From: Jennifer Pollitt [REDACTED]
Sent: 19 January 2022 16:14
To: Planning.Responses <Planning.Responses@arun.gov.uk>
Subject: RE: Planning Consultation on: LU/411/21/PL

Application No: LU/411/21/PL

Registered: 7th January 2022
Site Address: 90-91 South Terrace Littlehampton BN17 5LJ
Grid Reference: 502860 101608
Description of Works: Change of use from existing leisure use to 10No. 1-bedroom 1 person supported living apartments, staff office, staff sleepover, and associated ancillary facilities to include extension to form new first floor, alterations to roof space including creation of dormer windows & installation of roof lights. This application is in CIL Zone 4 (zero rated) as flats.

project	Proposed Development 90-91 South Terrace Littlehampton, W Sussex
detail	Proposed Elevations
drawn	MAS
date	Dec 2021
at scale	a3 scale
1:100	1:200
status	Planning
rev	28118-PD210

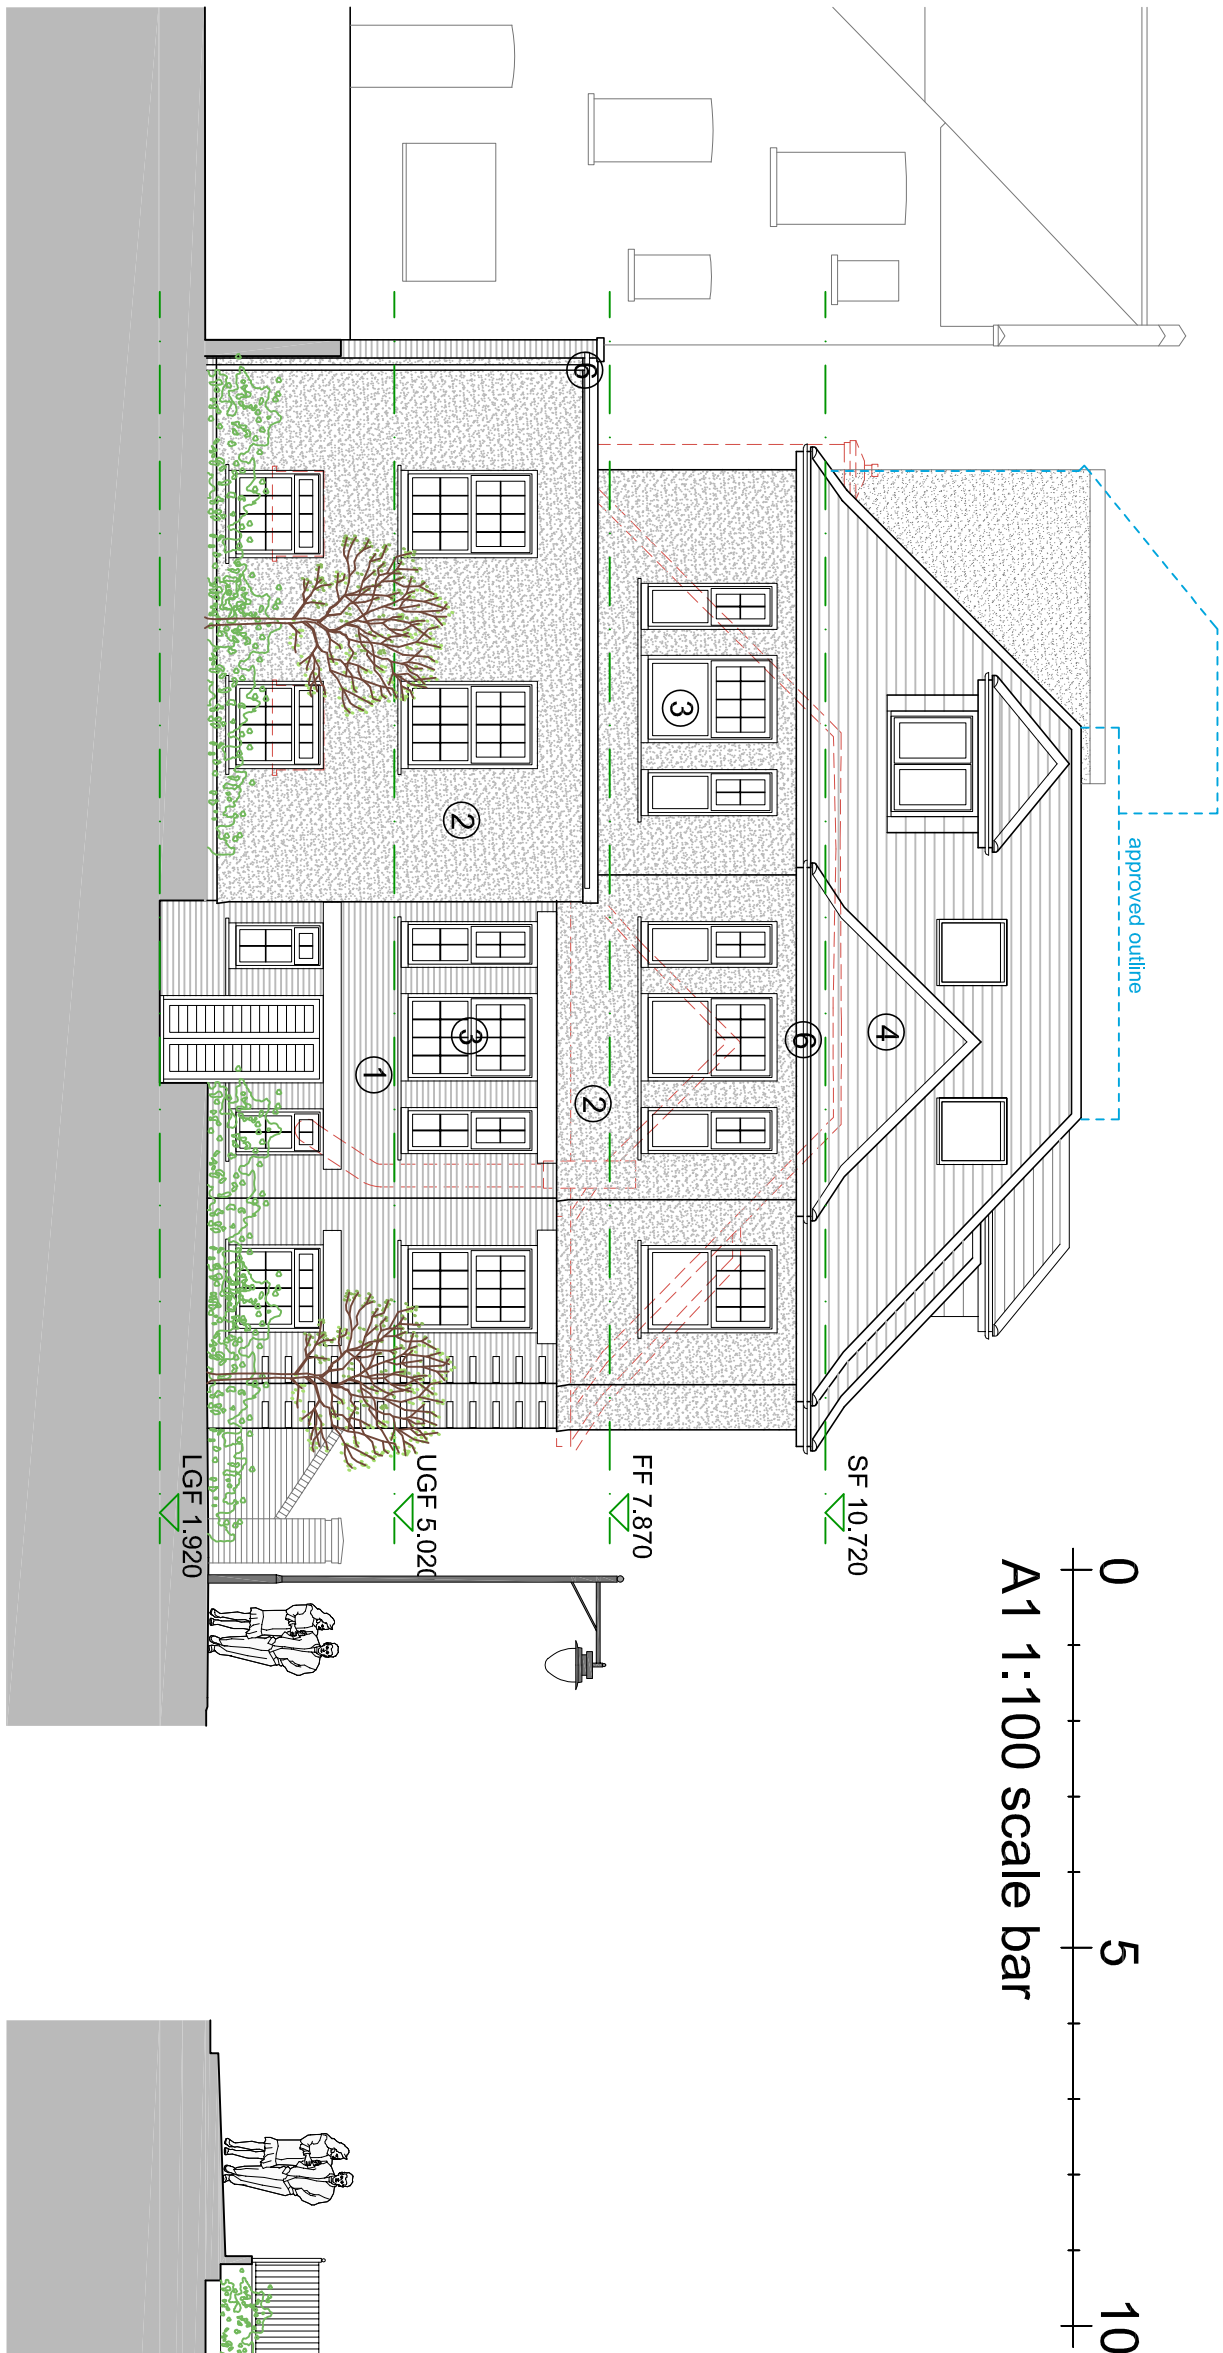
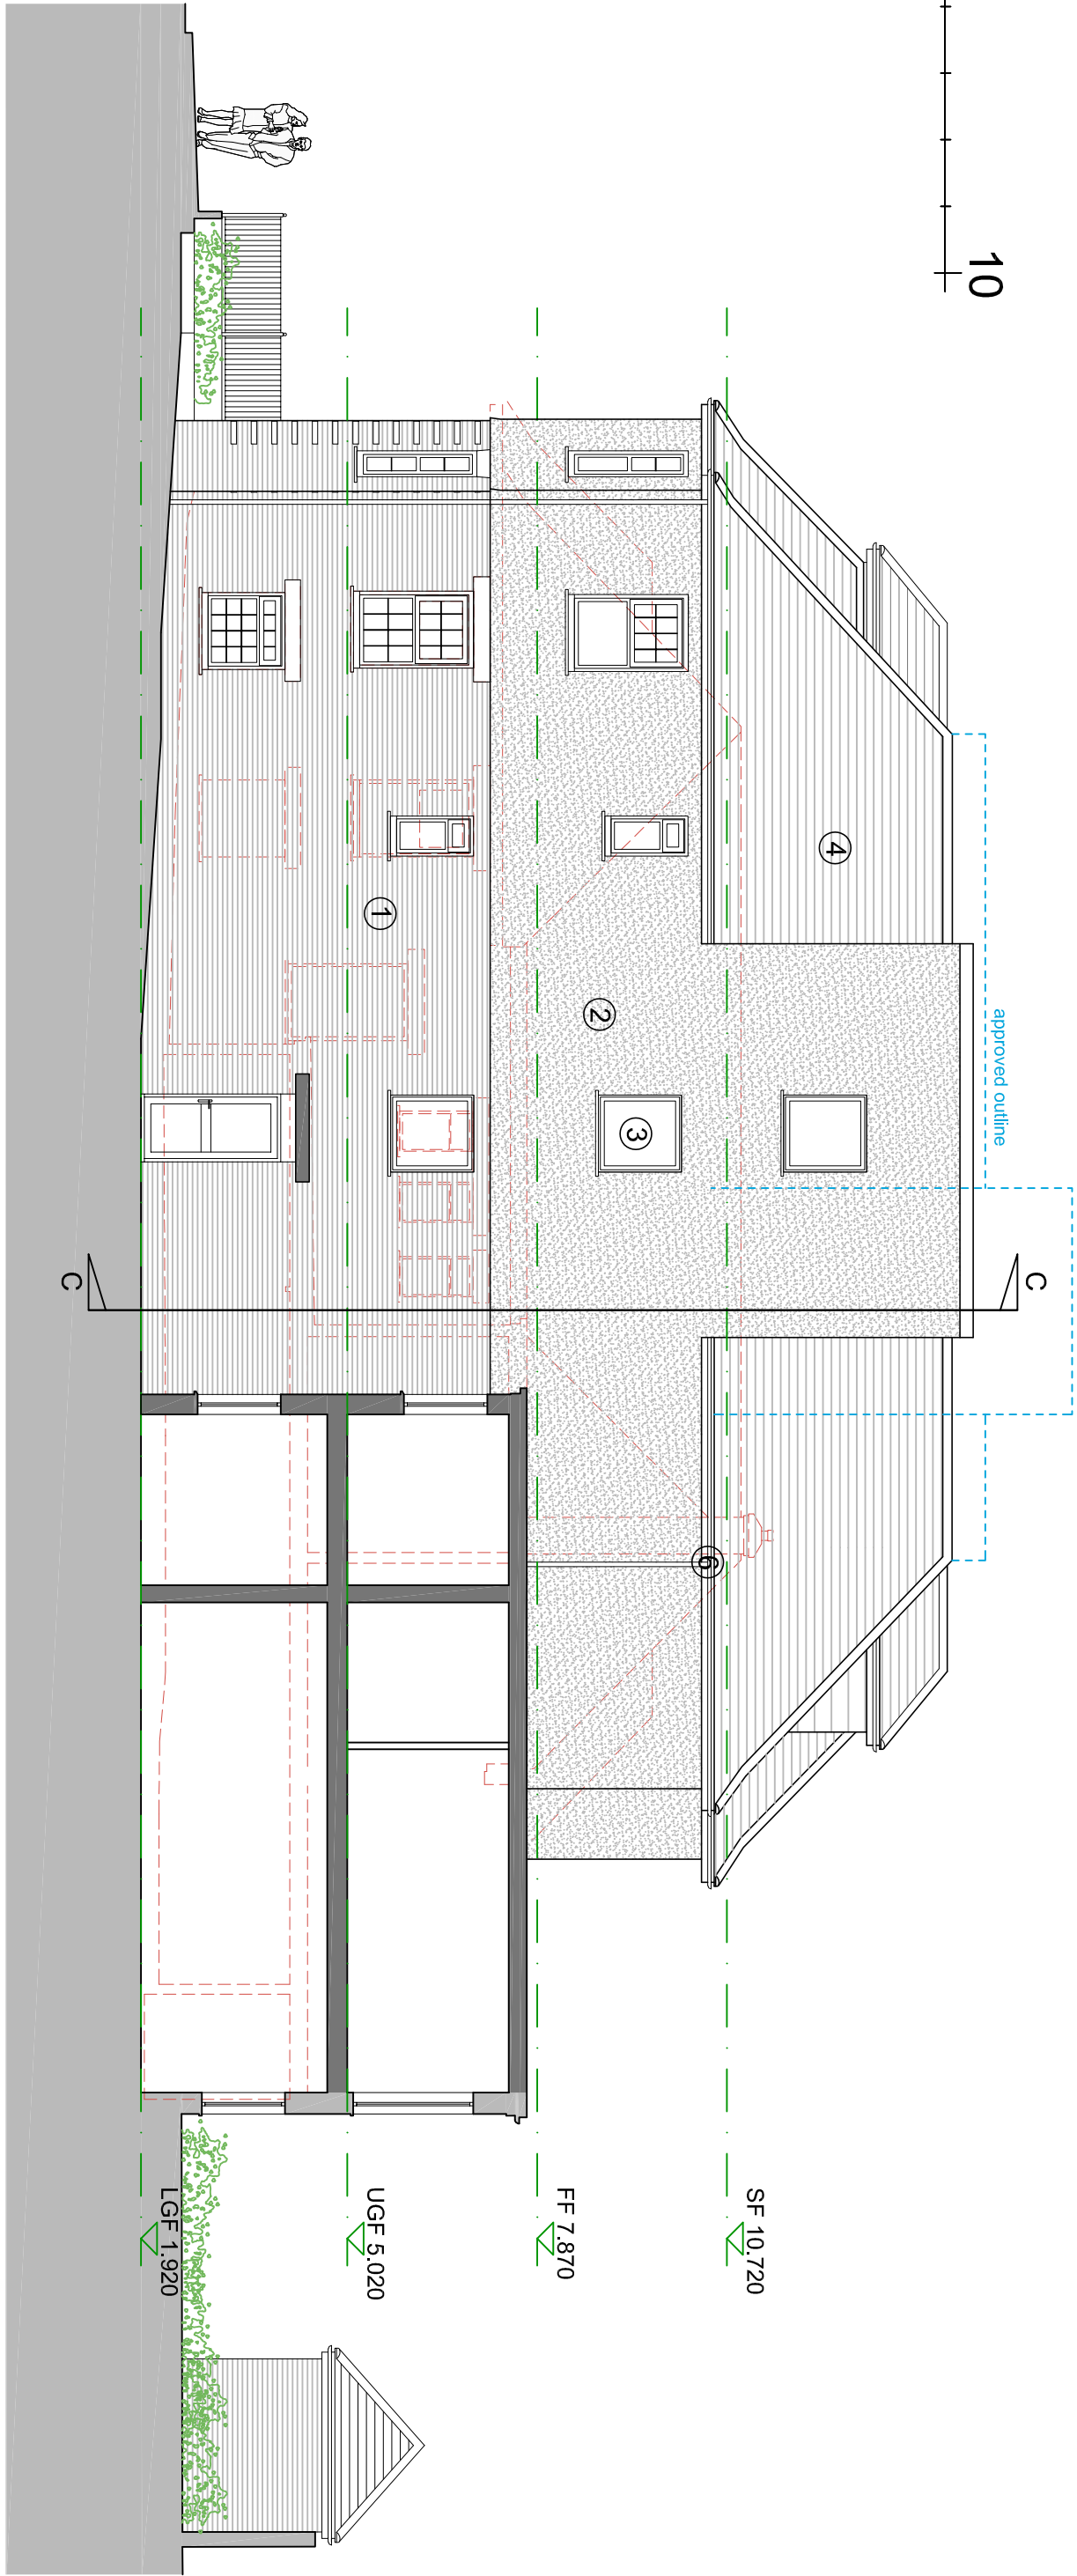
As per the Preliminary Roost Assessment and Bat Emergence Survey Report (July 2021) we require that 2 bat boxes are installed on the building onsite facing south/south westerly positioned 3-5m above ground.

We would like two bird boxes to be installed on the building and/or trees within the garden of the property.
